Re: PROPOSED EXTENSION TO THE JOLLY CRISPIN P.H. MARRIOTS GATE LUTTON
FOR MR M E BUNN

Description: Details of acoustic fencing,
landscaping and car parking
(Conditions 3, 4 and 6 of
H12/0111/95)

Amendment: Details of car parking arrangement changed to allow grey
alder tree to remain (drawing number 771805/4)

Amendment: 1.8 metre high fence to southern boundary
(drawing number 771805.4)

E - FENCE ADDED - 14.11.95
D - CAR PARK ALTS - 14.9.95

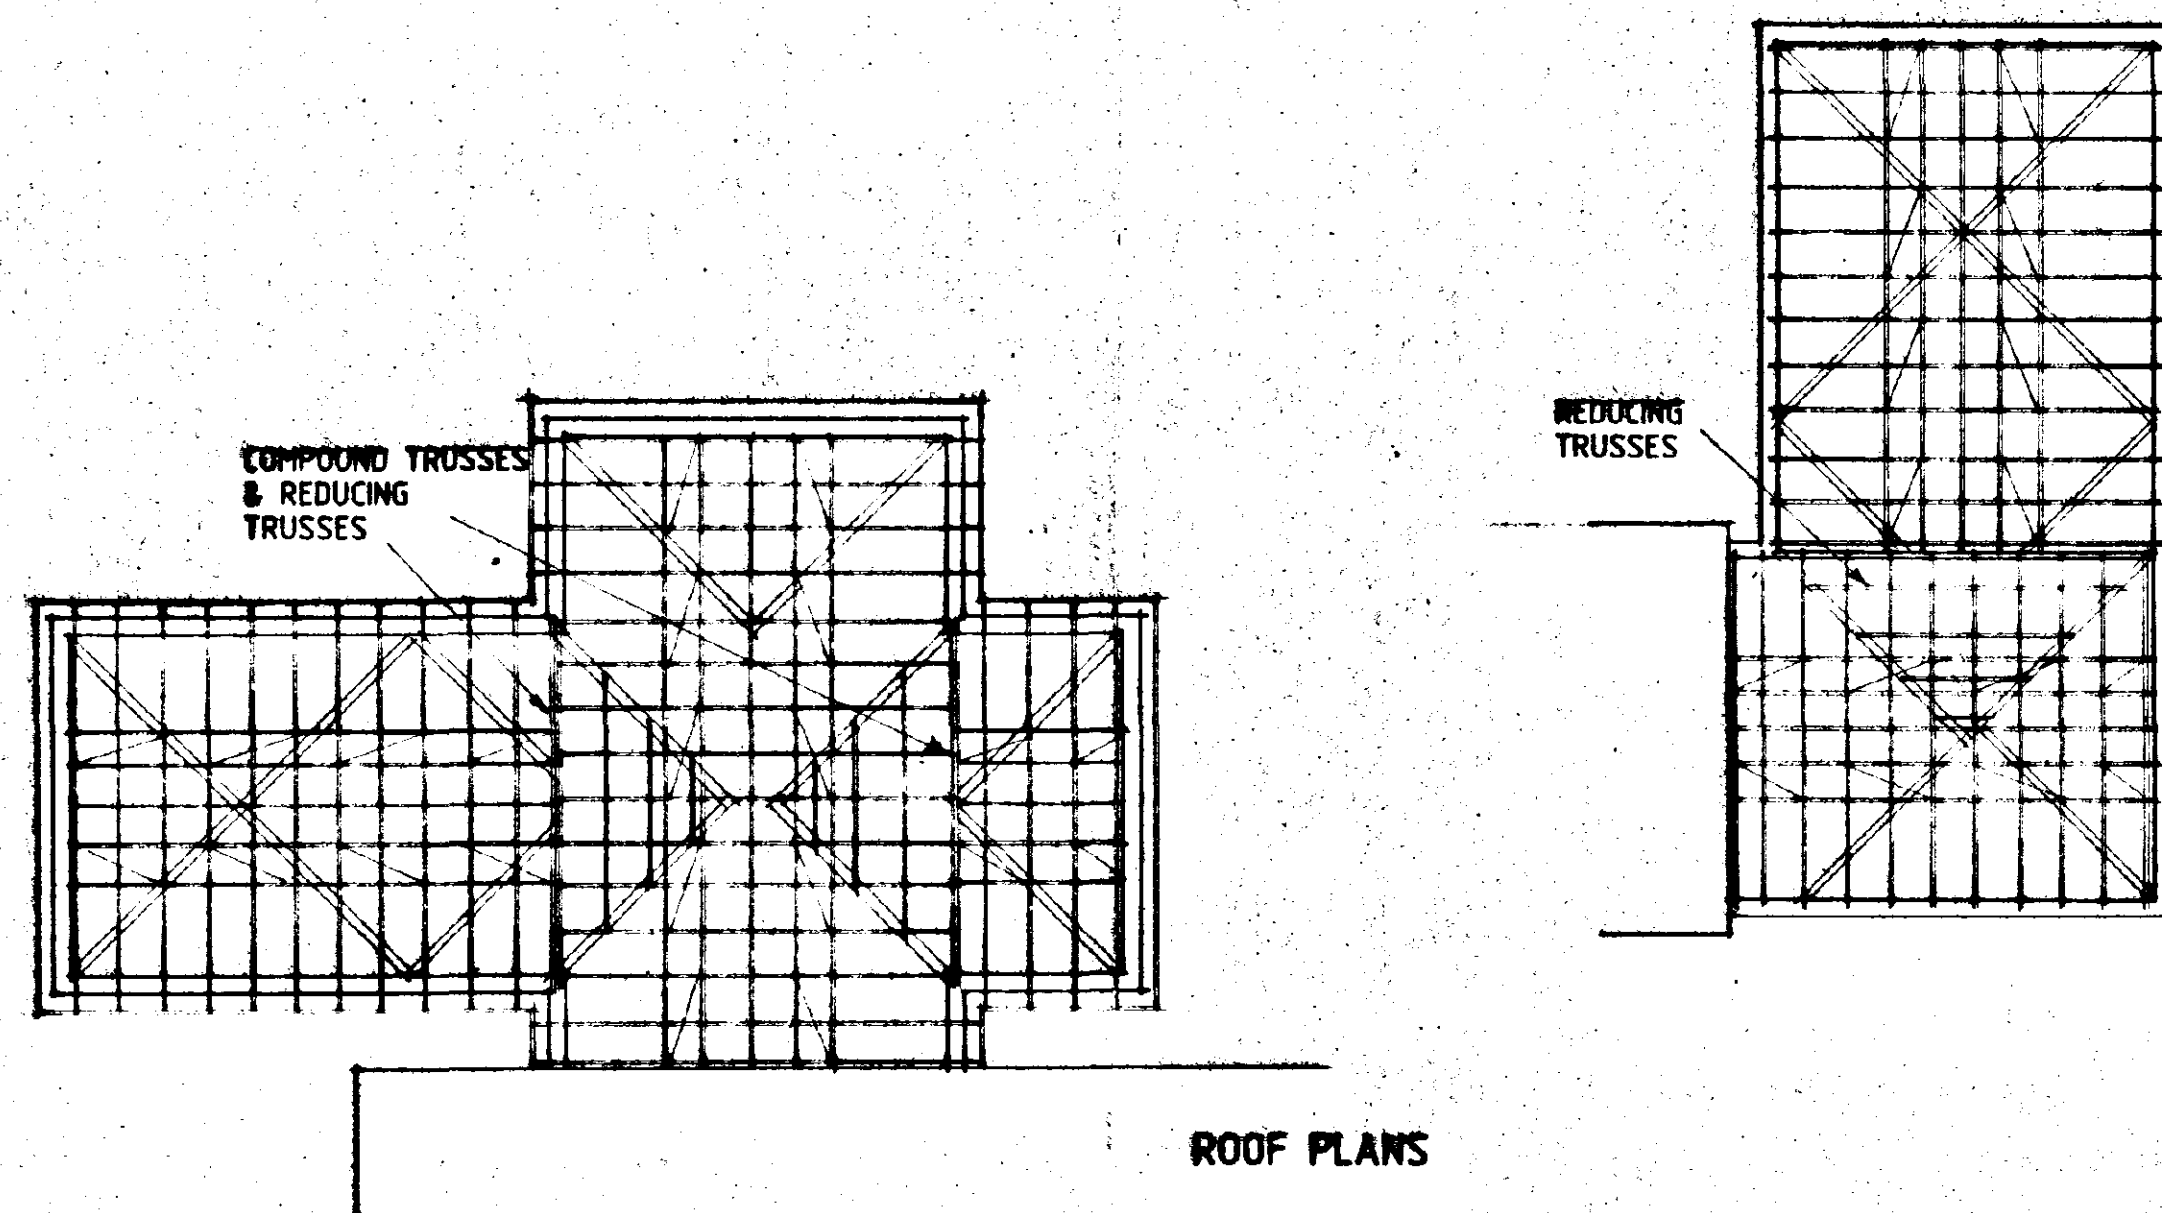
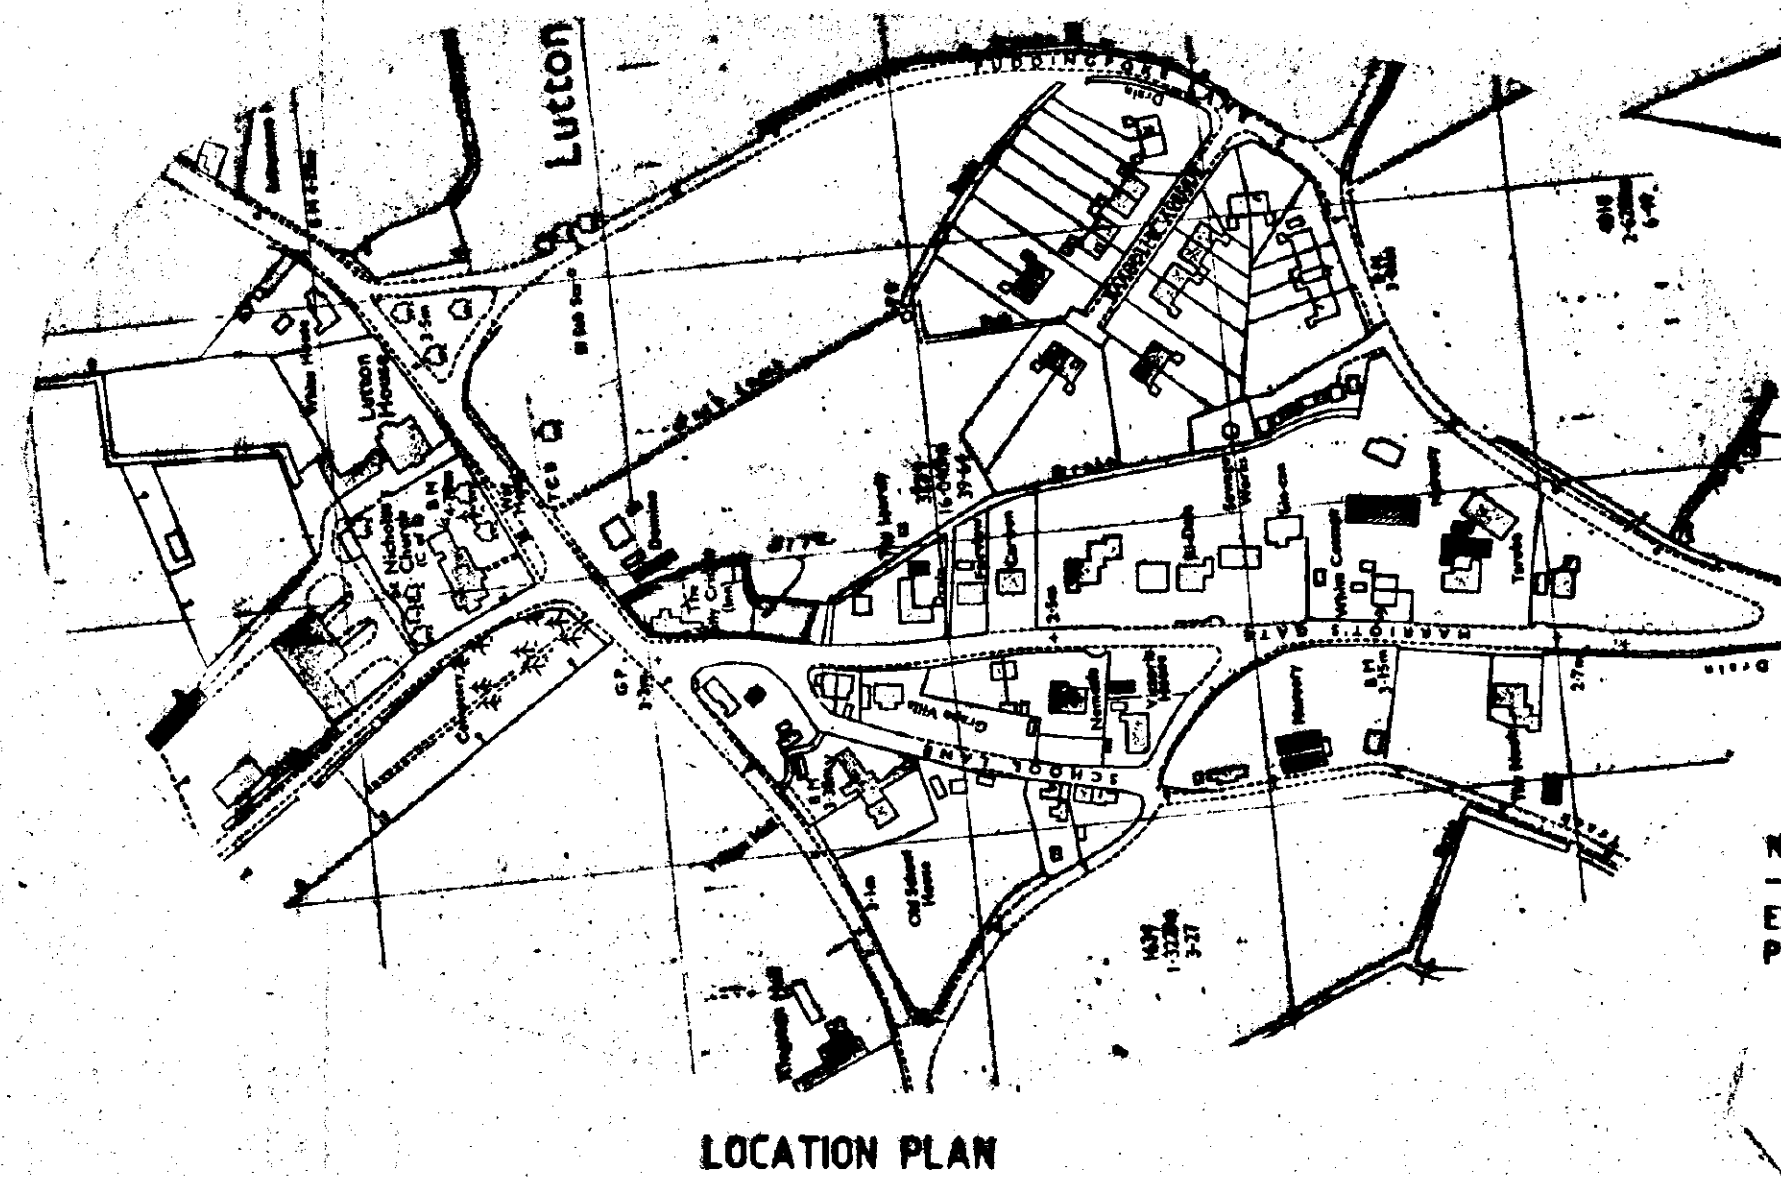
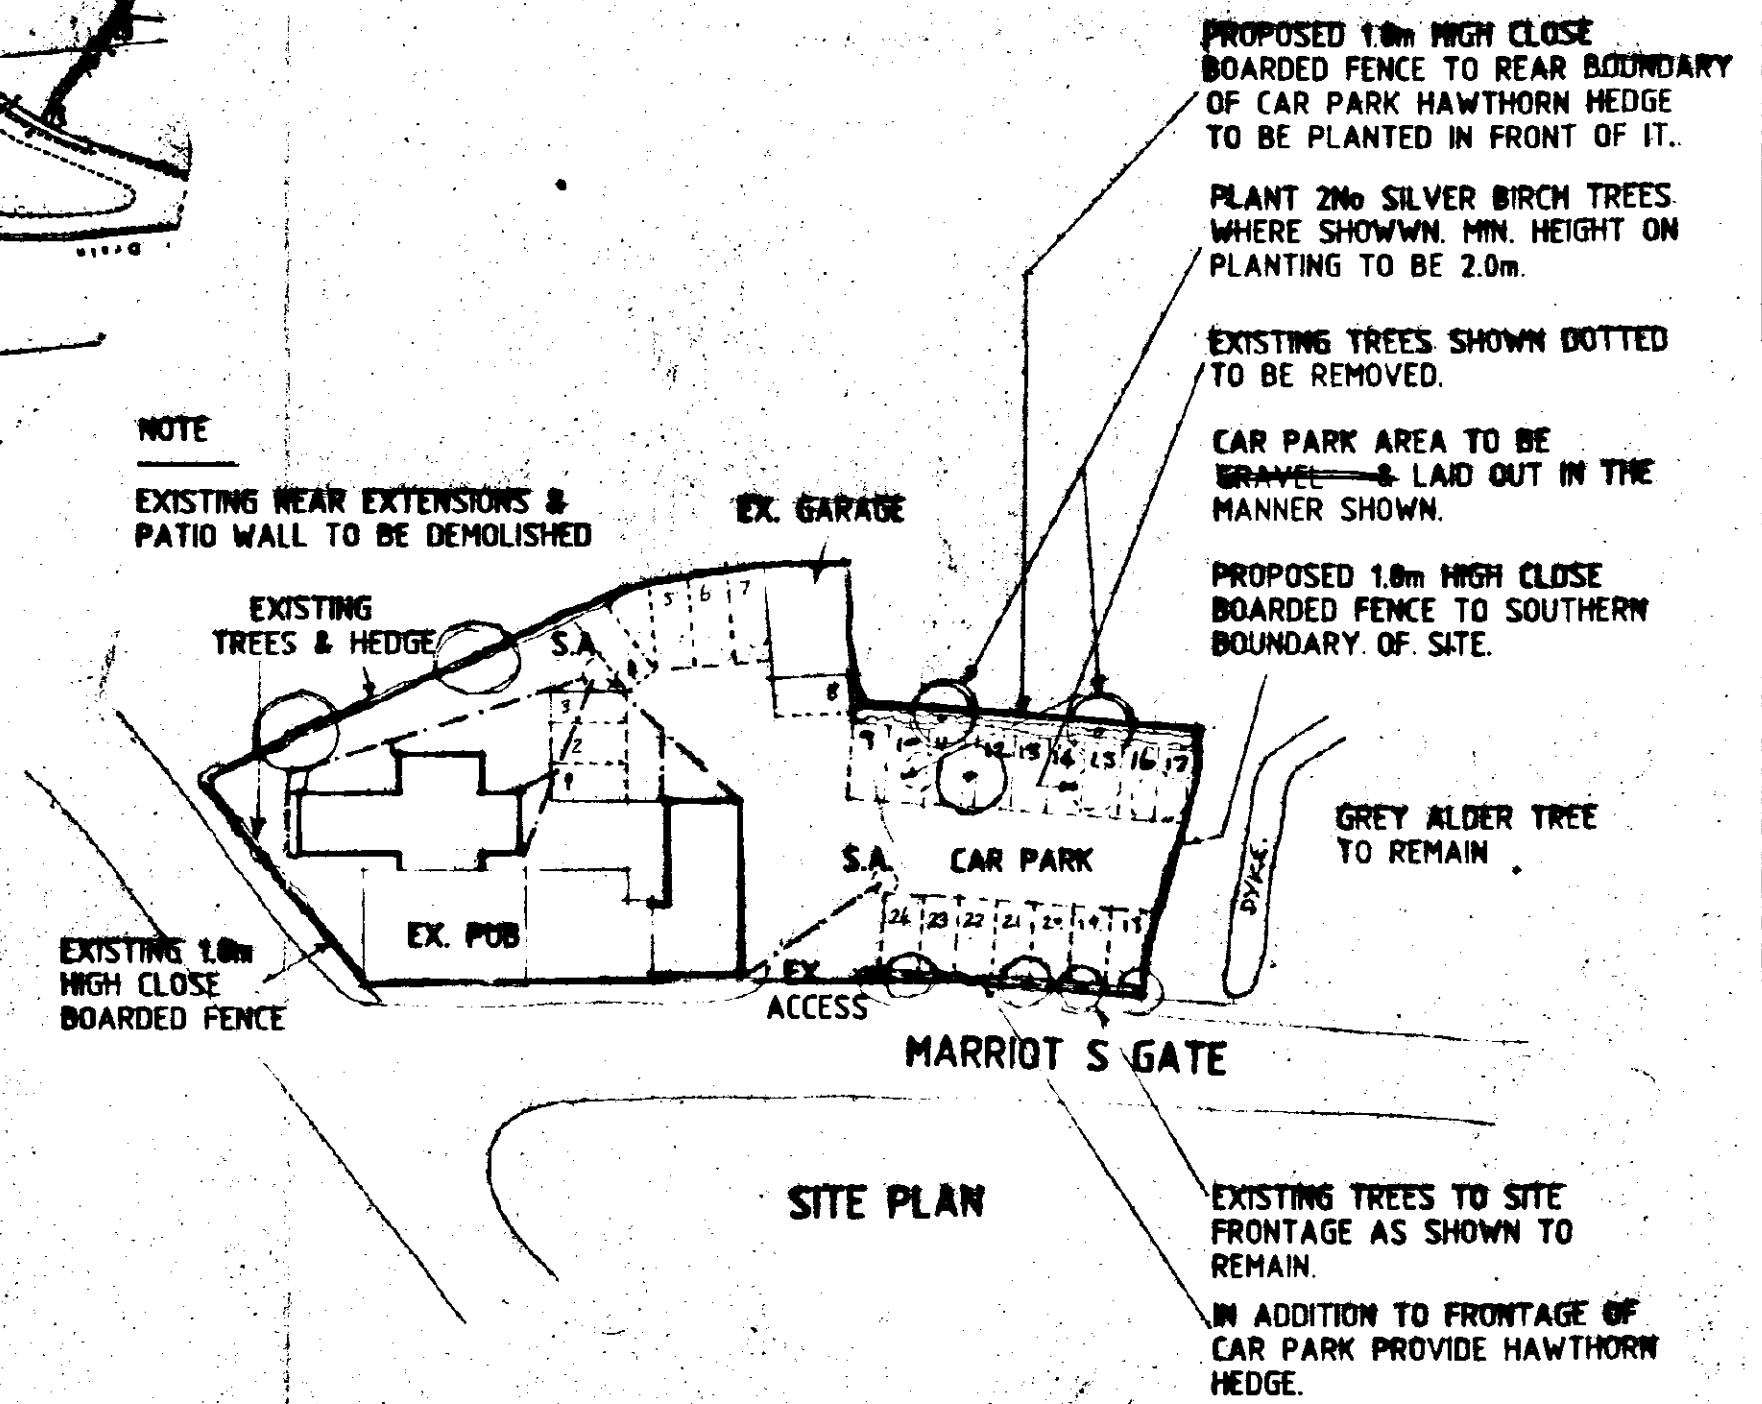
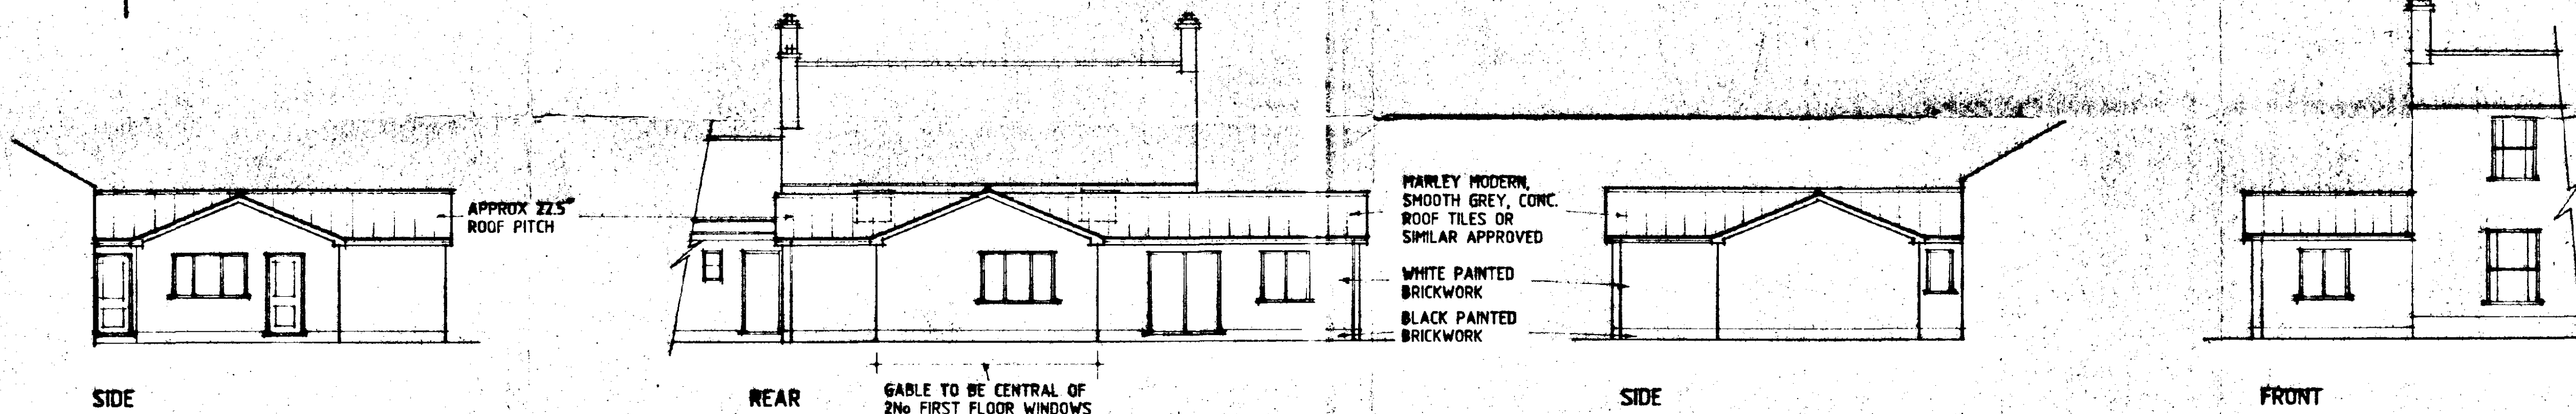
Carparking arrangement changed
to allow grey alder tree to
remain

In respect of your letter dated 9th August 1995, I enclose 4 no. copies of amended drawing no. 771805/4 showing car parking arrangements adjusted to show grey alder tree to remain as required.

1.8m high fence to southern
boundary

Further to your letter dated 10th November 1995, I enclose 4 no. copies of revised drawing no. 771805/4 showing fence to the southern boundary as required together with duly completed Planning Amendment forms.
